**Comments appertaining to  
ESSO's Site Specific Plans  
for SCP**

**Application by ESSO Petroleum Company Ltd  
for an Order Granting Development  
Consent for the Southampton to London  
Pipeline Project**

**Application Reference EN070005**

## Southwood Country Park Site Specific Plan

Drawing title:
8.60 SSP SOUTHWOOD COUNTRY PARK: REINSTATEMENT SHEET 3 OF 3

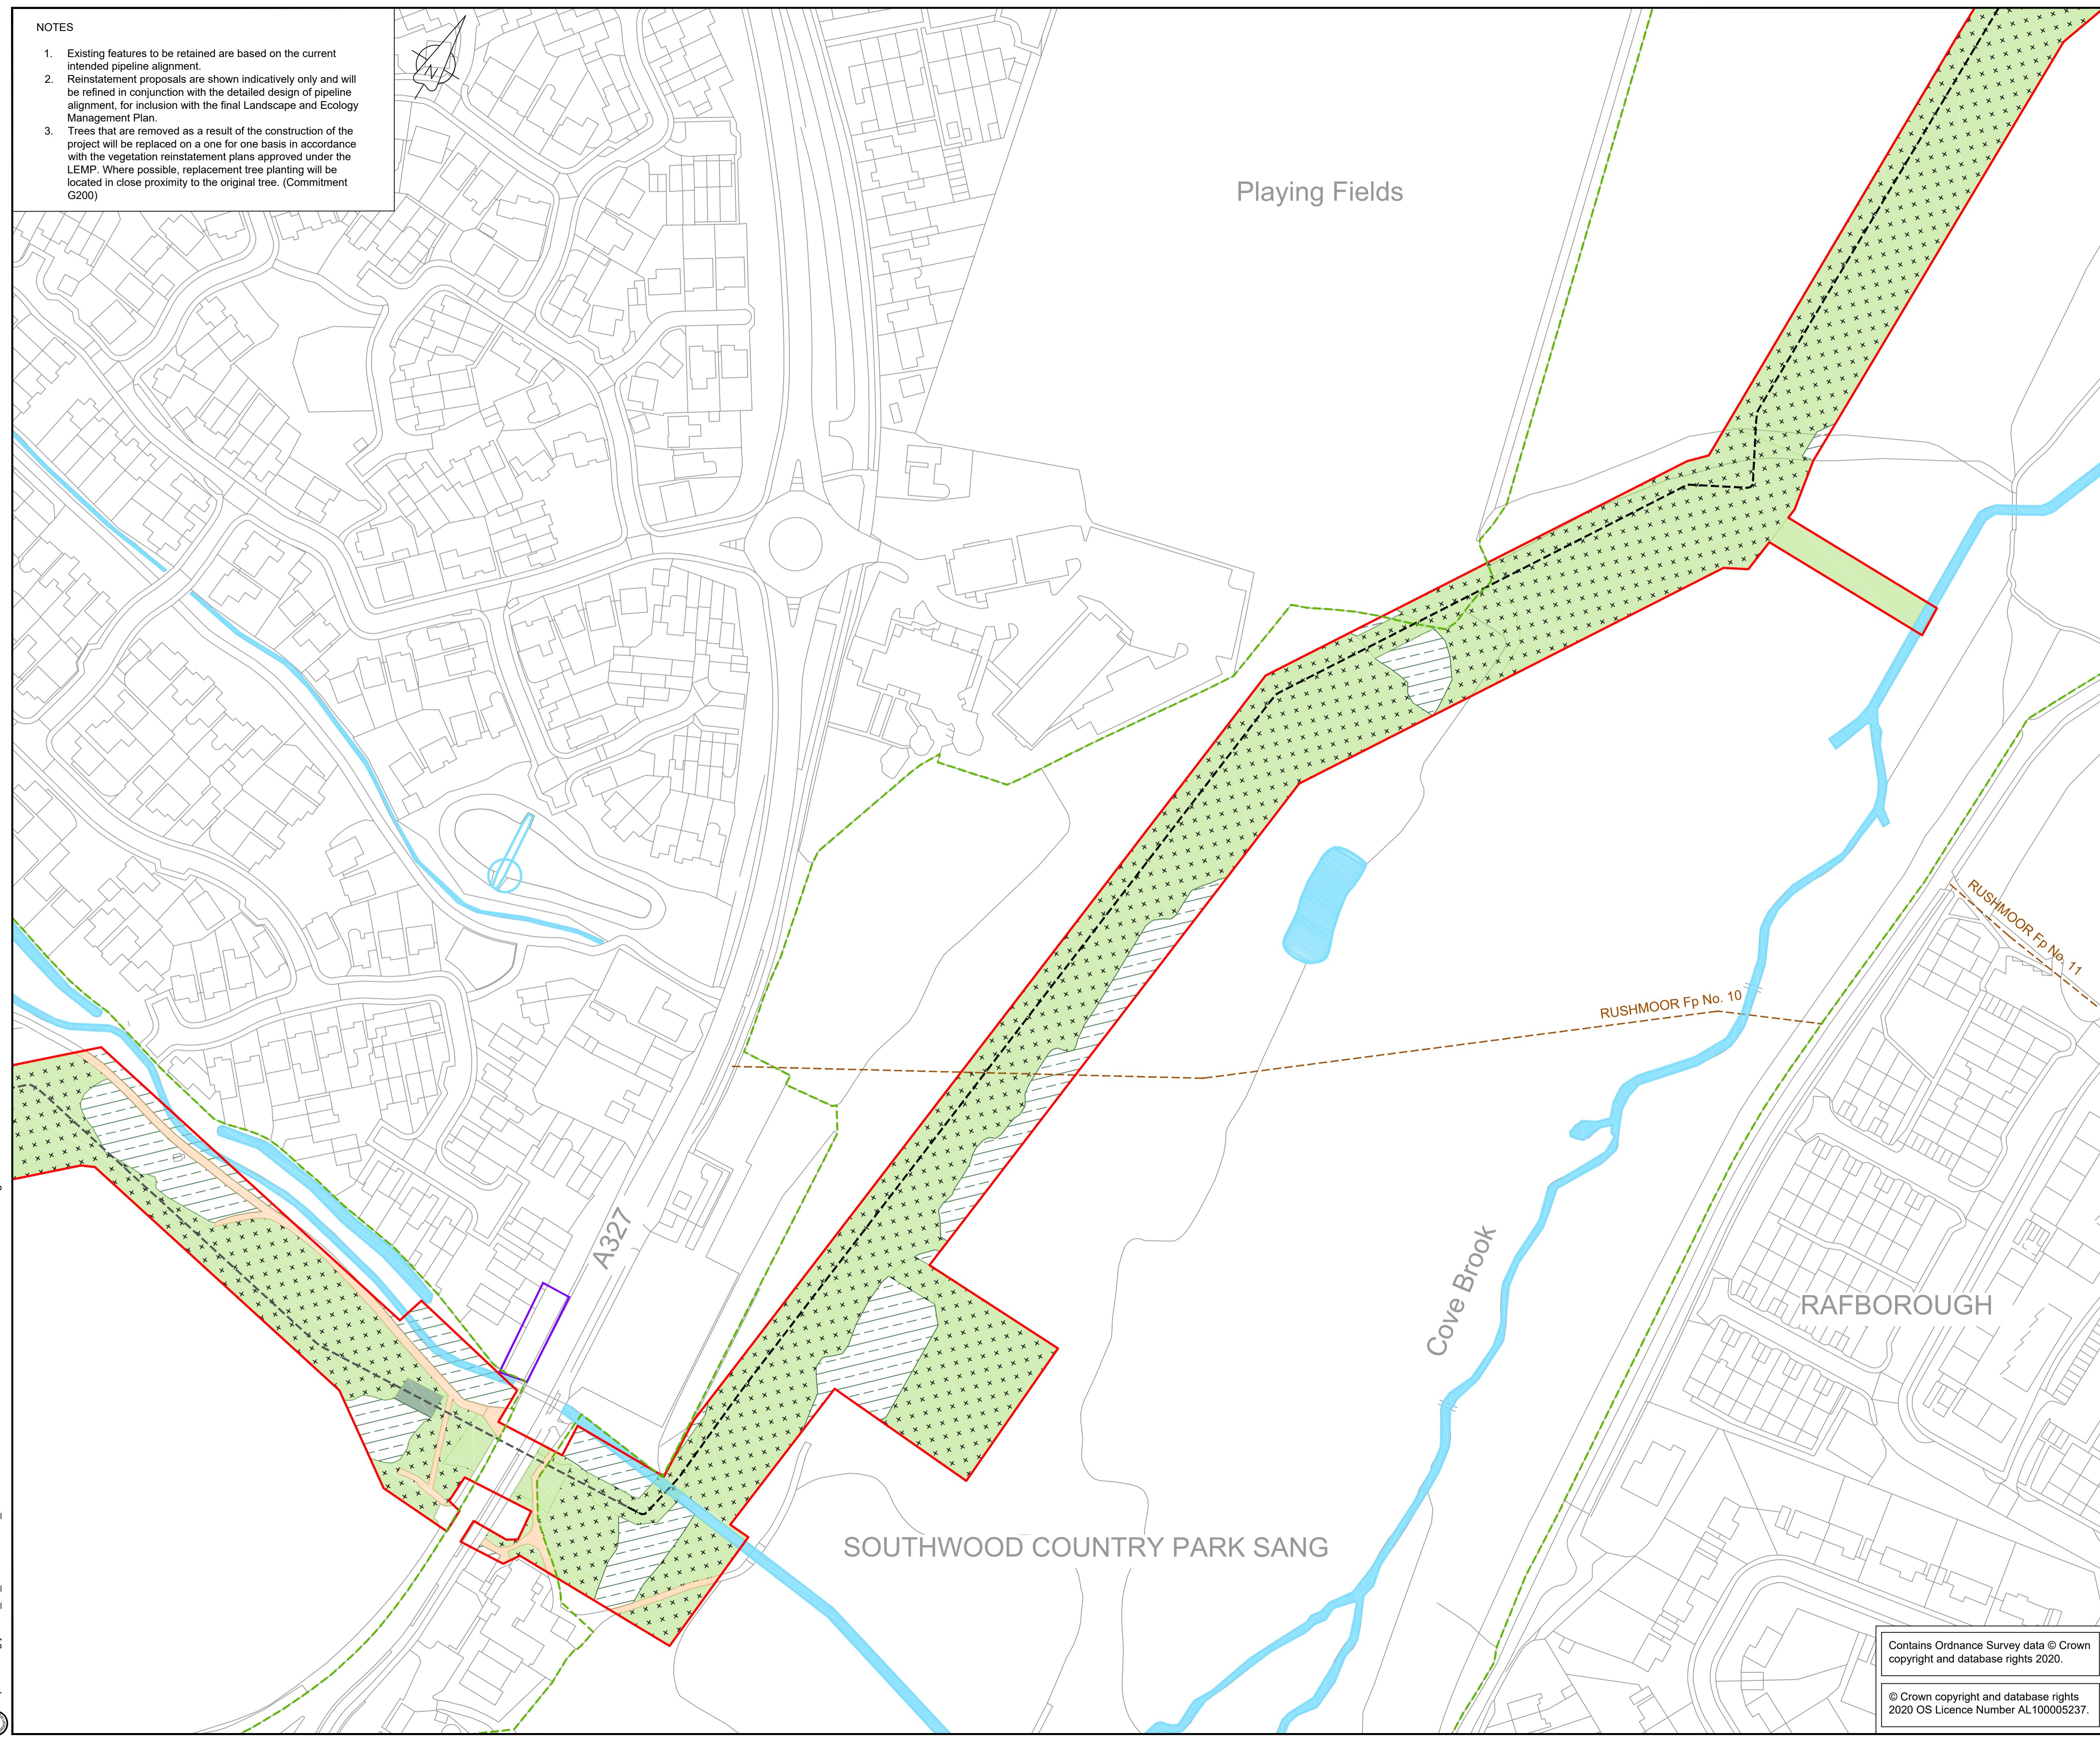
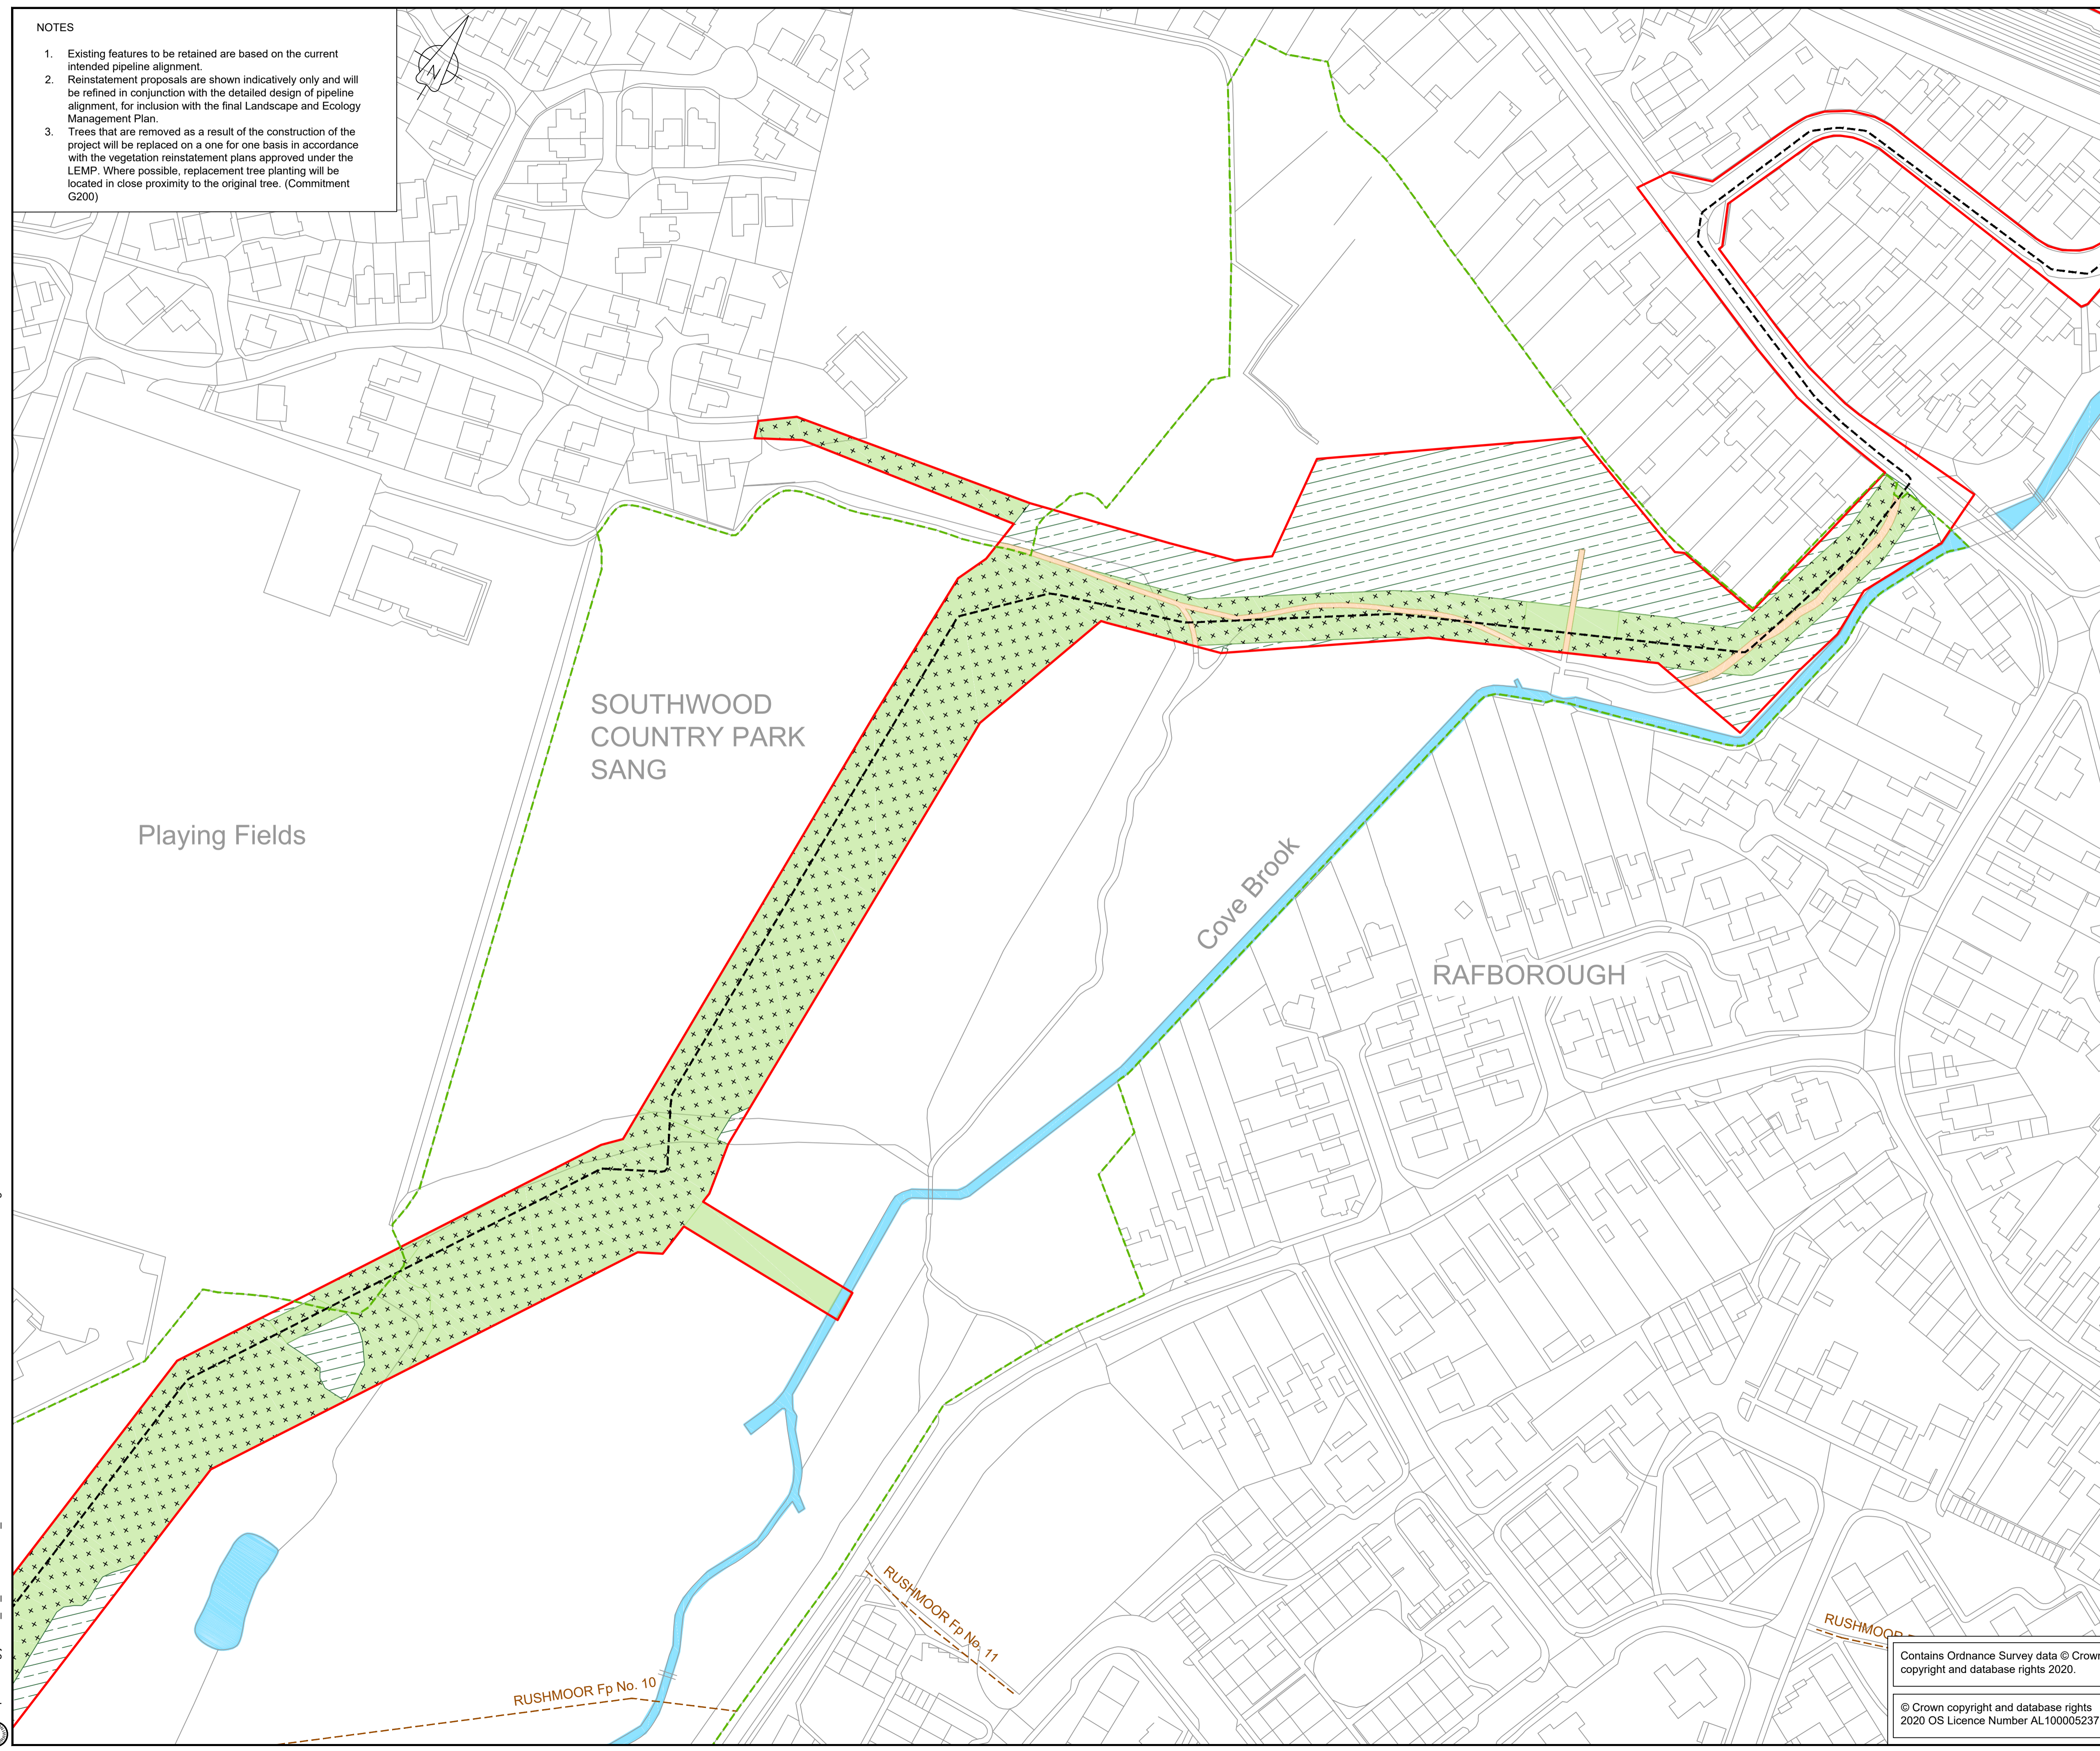
- 7.1.1 RBC is pleased to note that seed collection and sowing is proposed as part of the mitigation of loss of acidic grassland and marsh habitats. We are also pleased to note that updated surveys will be undertaken within the acidic grassland habitats to the east to establish biodiversity value. To mitigate the loss of maturity within the habitats additional habitat should be provided. The council have identified works

within Southwood Golf Course West SINC and Southwood Woodlands for additional marsh and acidic grassland habitats respectively. However as this is mitigation to ensure no biodiversity loss RBC is still of the opinion that area of habitat to be provided should be determined by a biodiversity offsetting calculation, with delivery of the habitats secured as part of a s106 agreement. The majority of the works will be undertaken as part of the project and therefore do not require additional funding.

7.1.2 Within the Cove Brook SINC and the Cove Brook Southern Grassland SINC the habitats currently present are associated with marshland rather than acidic grassland. Therefore we would require seed collection from these areas in the autumn immediately before the works, with habitat restoration being undertaken in the first available season.
